SF19014-R2-Plat-Redlines Summary_Markup Summary

ENG-SF19014-R2-TIS-Redlines Summary_Markup Summary

ENG-SF19014-R2-MDDP-Redlines Summary_Markup Summary

# BENT GRASS RESIDENTIAL FILING NO. 2

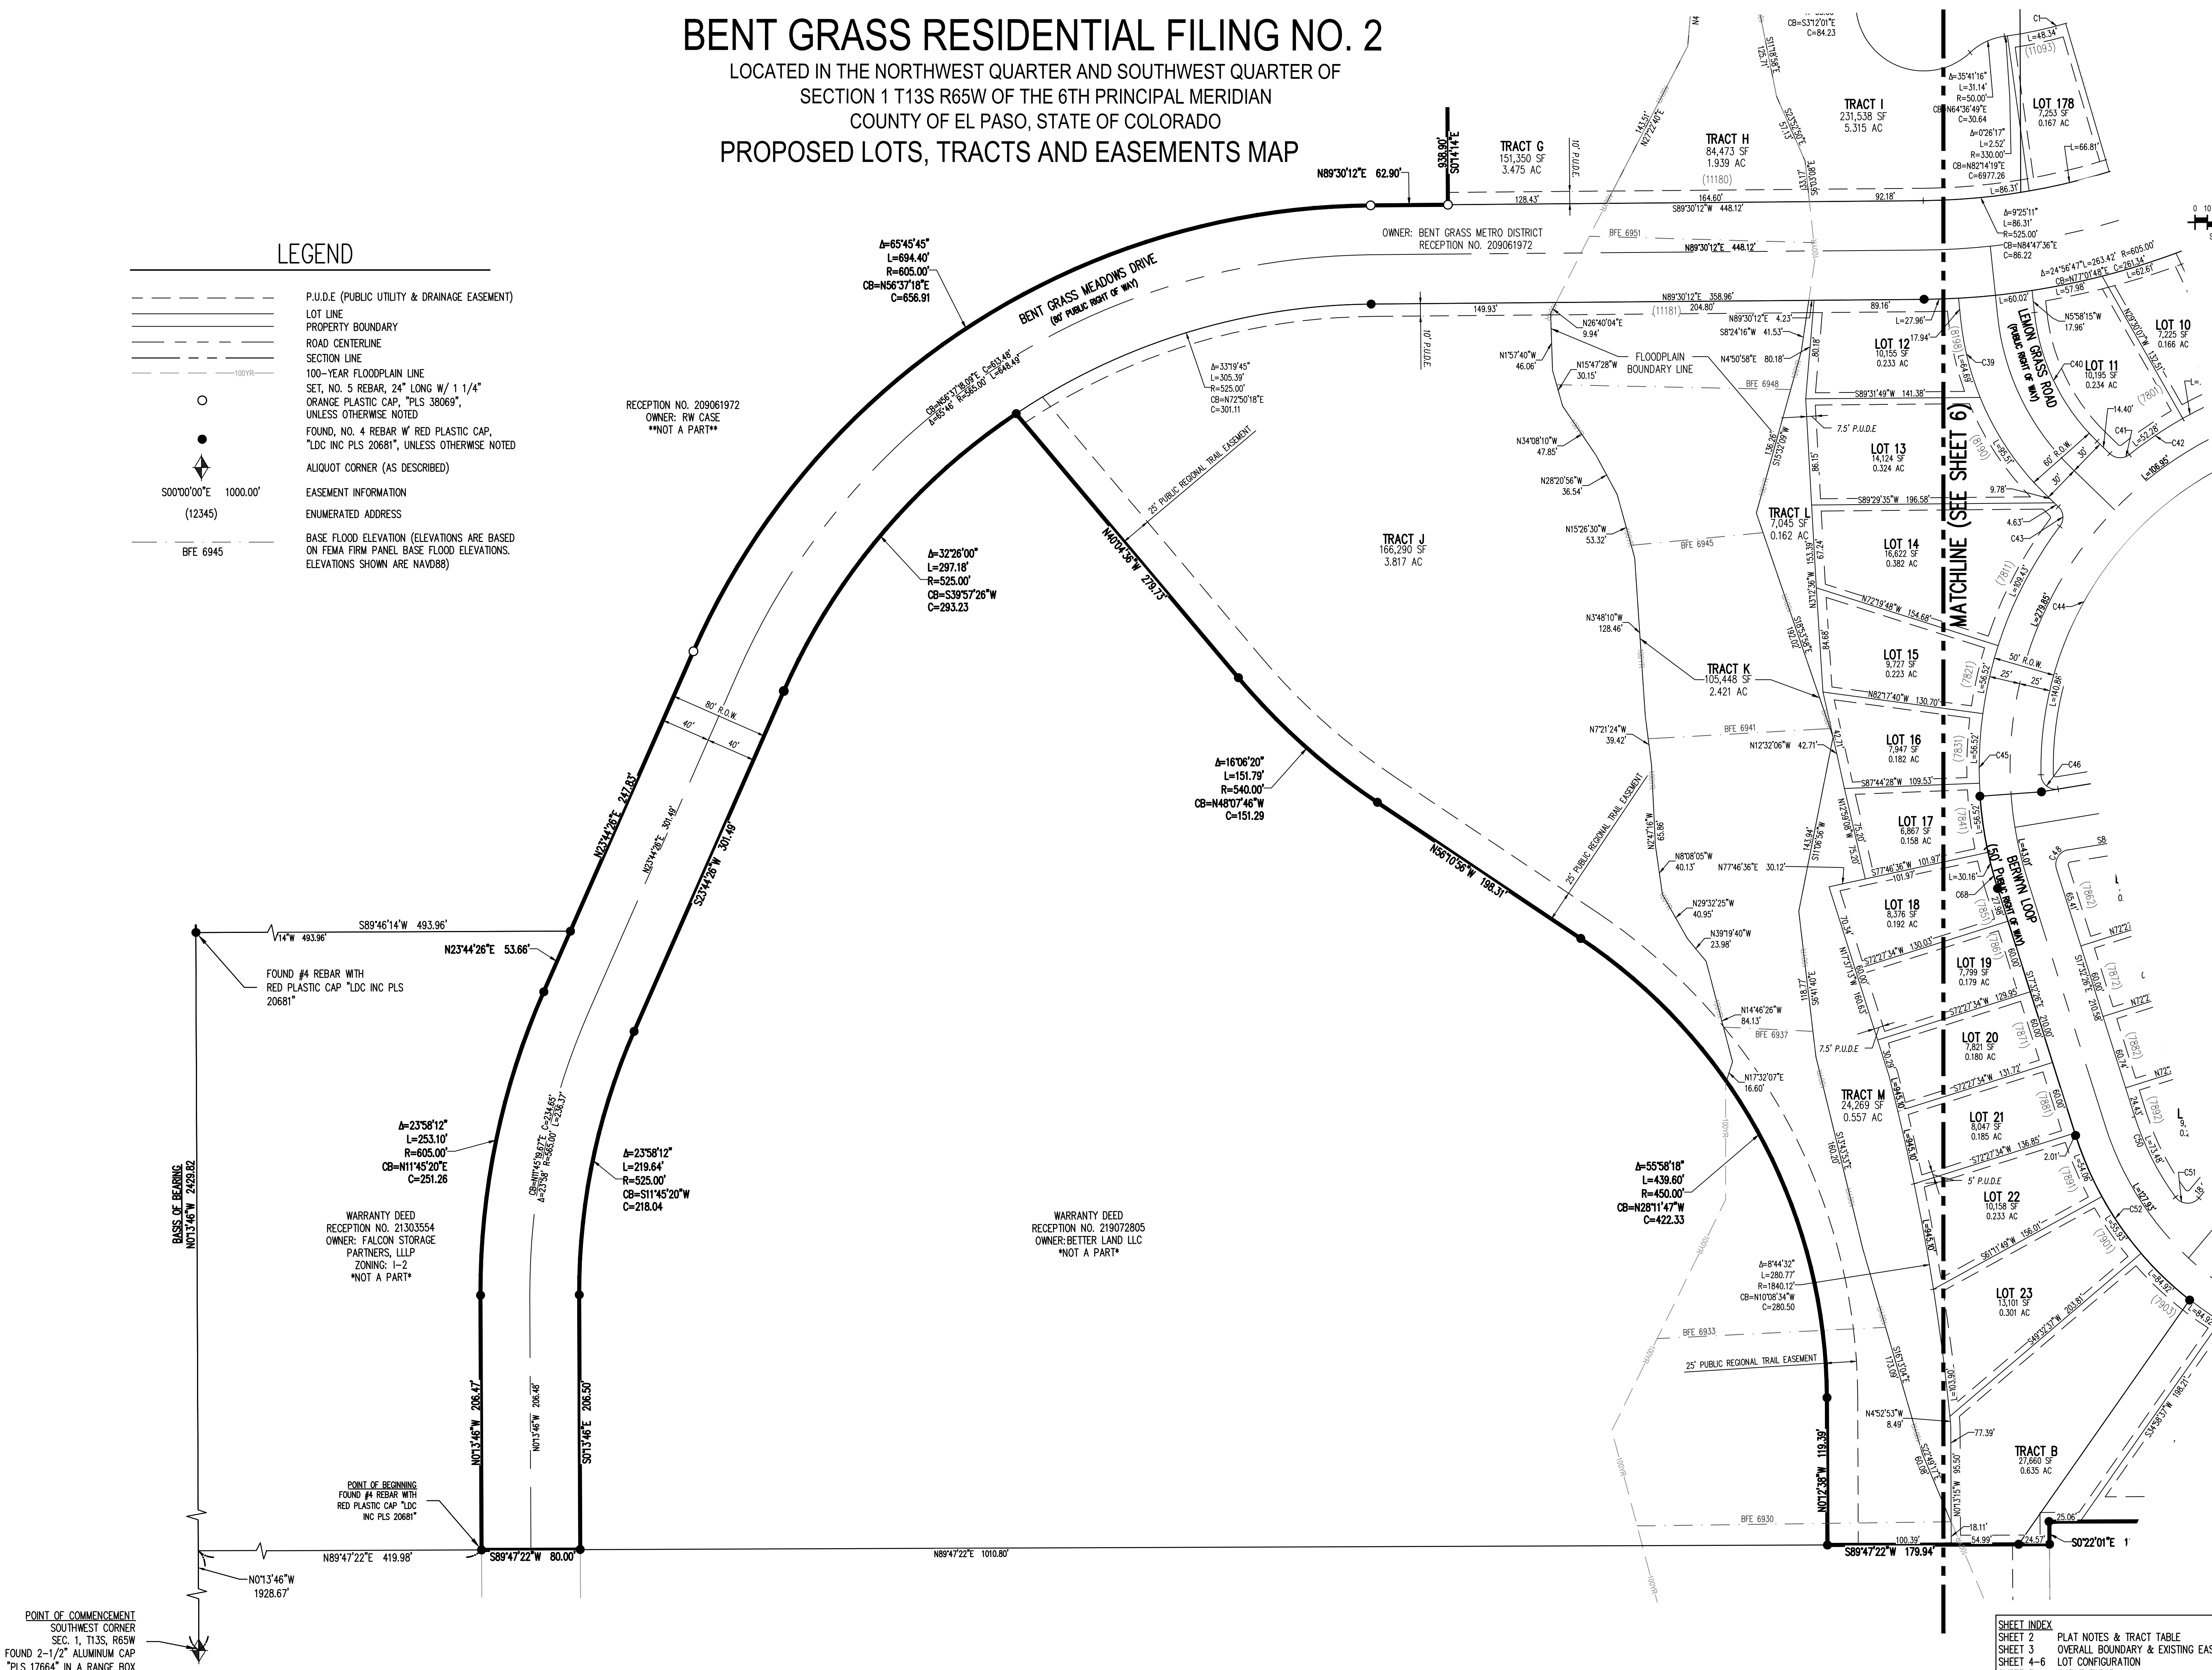
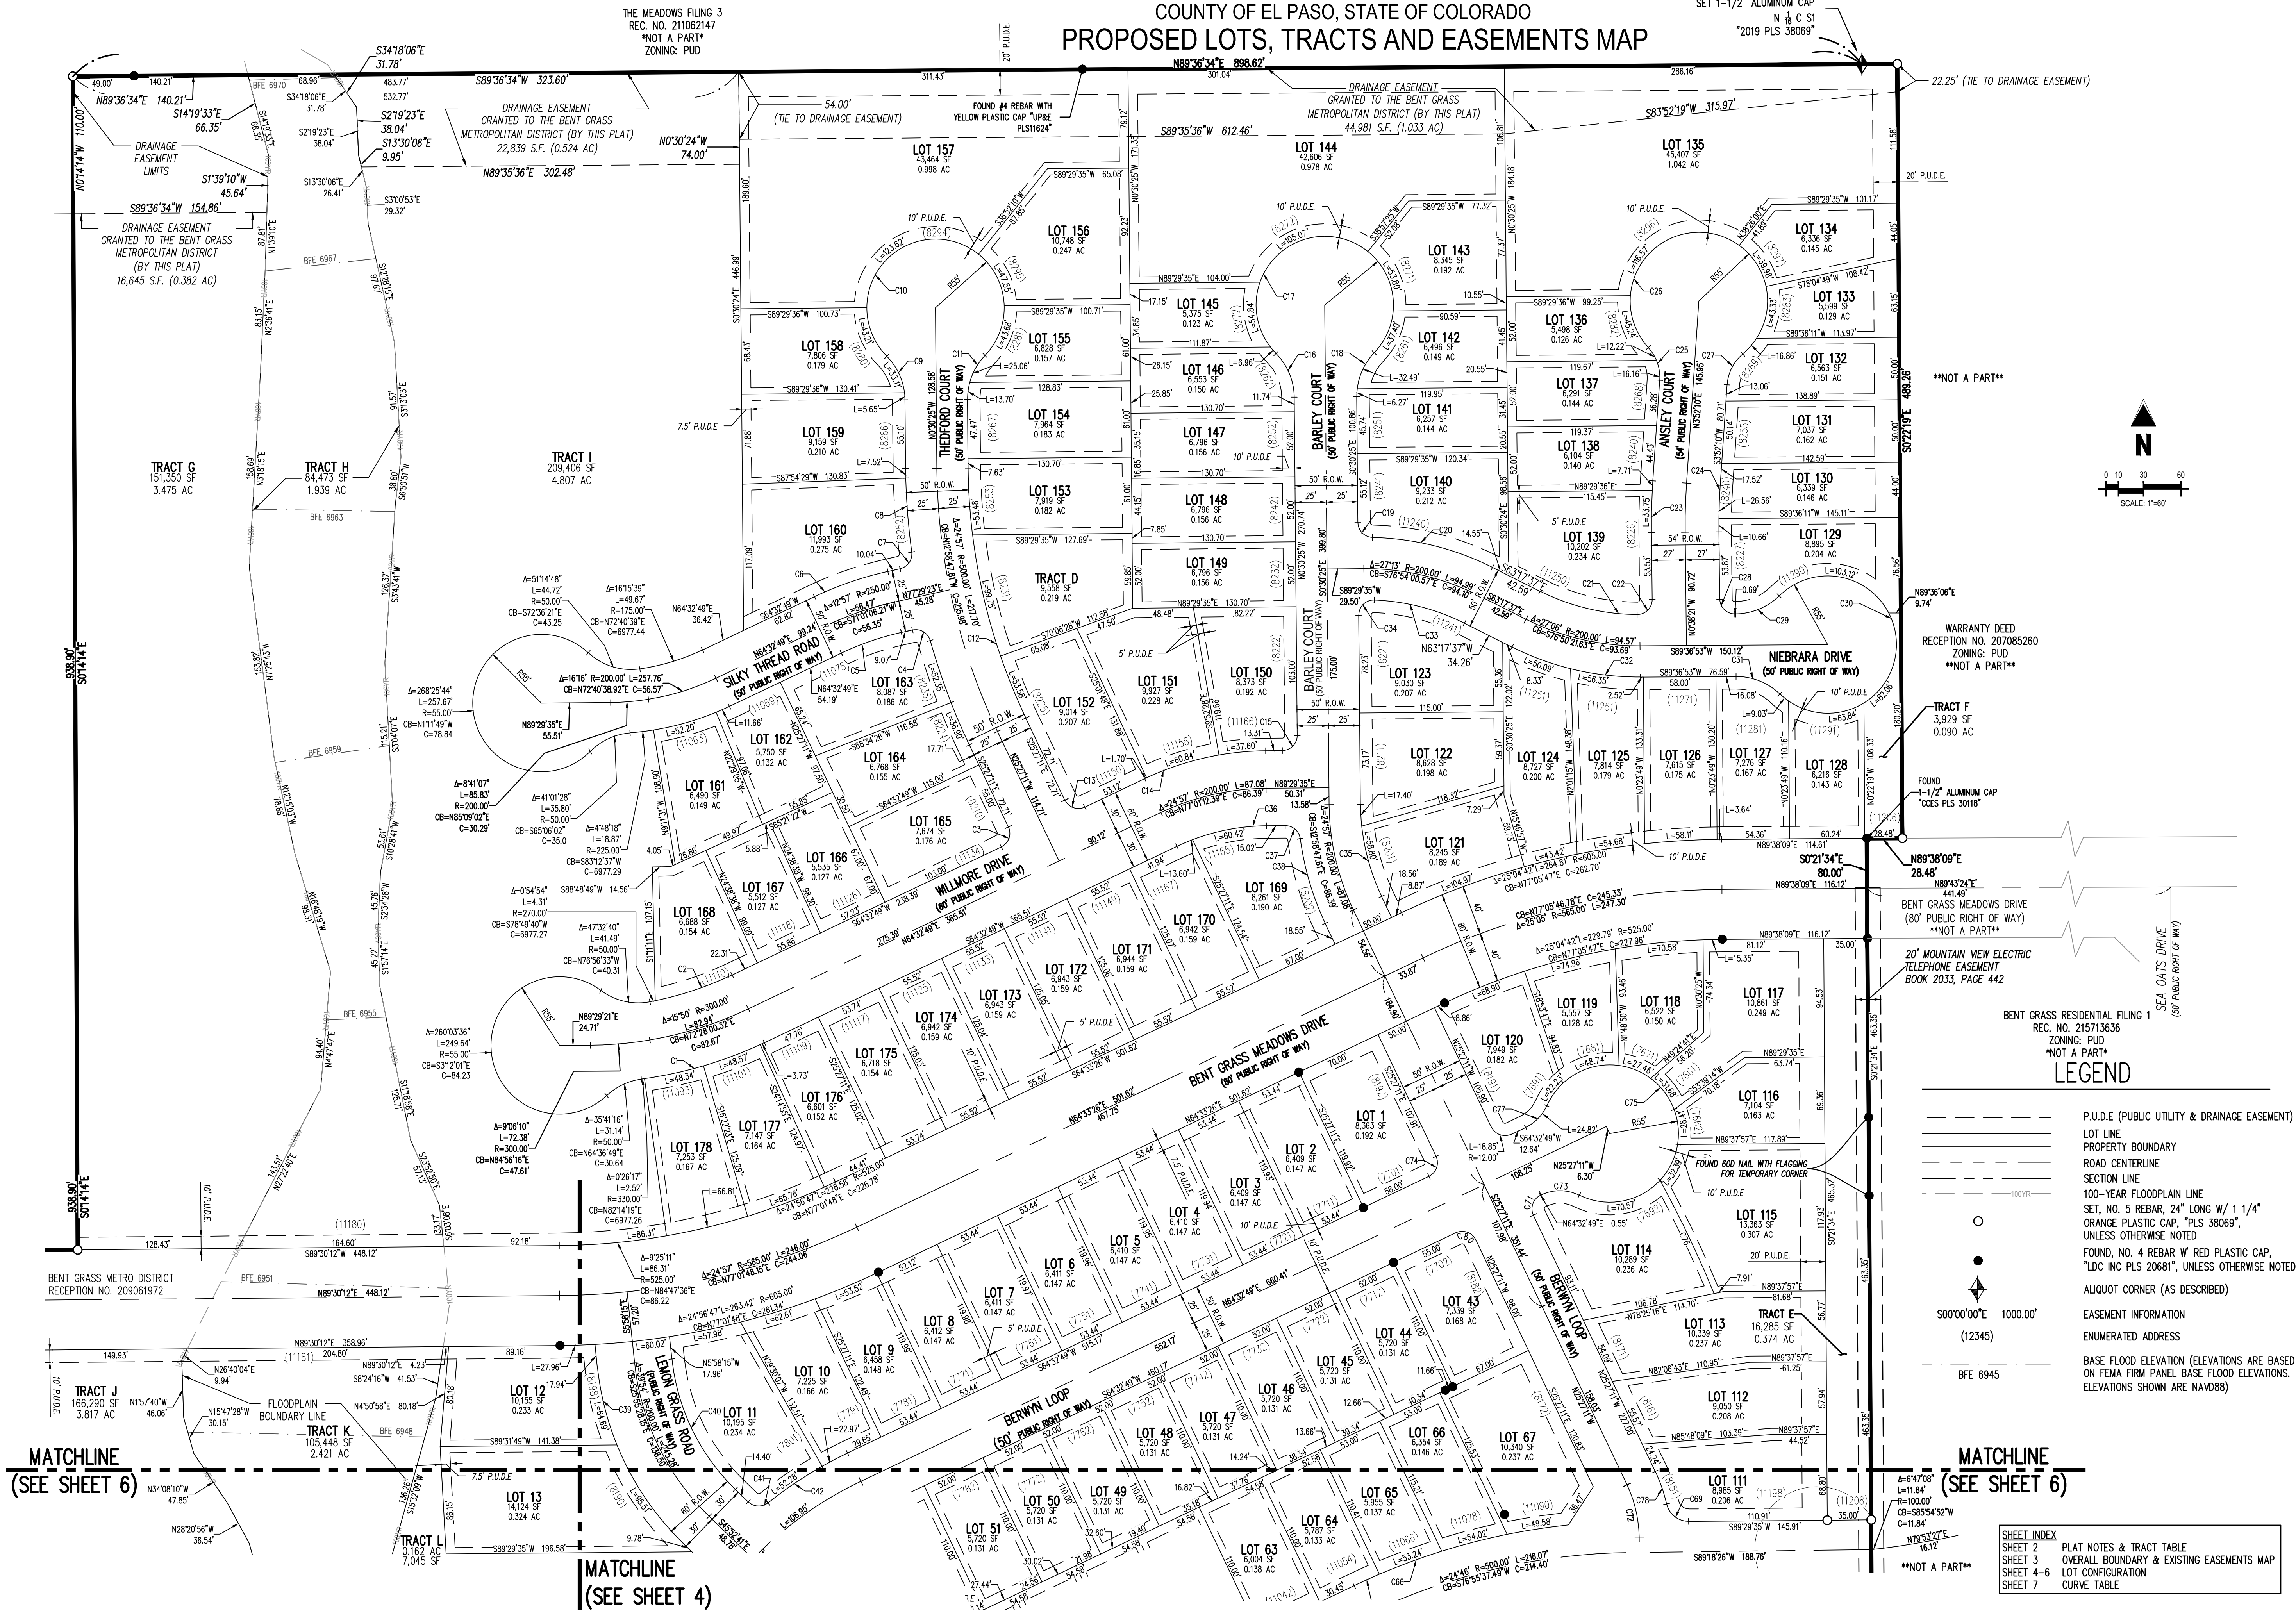
The drainage needs to be in tract- its to be maintained by ____ and the drainage tract will not be developed in the future but the other land adjacent will be - label remaining future development tract outside of the drainage tract. trail connectivity through drainage tract. This is the final plat, all easements, trails drainage ways, open space tracts must be depicted. Plat the drainage in a tract and that will increase the open space

Plat the lots and cul de sac here - Why would you leave empty space and come back in later to plat-Channel improvements whether stabilization or CLOMR must be addressed with the plat's drainage reprot.

put the floodplain in a trct by itself- show the required elevations

isnt there a large drainage easement here along the nrth heading west? State who is going to maintain this offsite easement if your not platting as a tract with this plat

finish road and lot lines or culdesac this? lots may be more efficeint

is there a pond here? are you keeping?

We discussed putting a trail accross here- this would tie in to the development to the west.
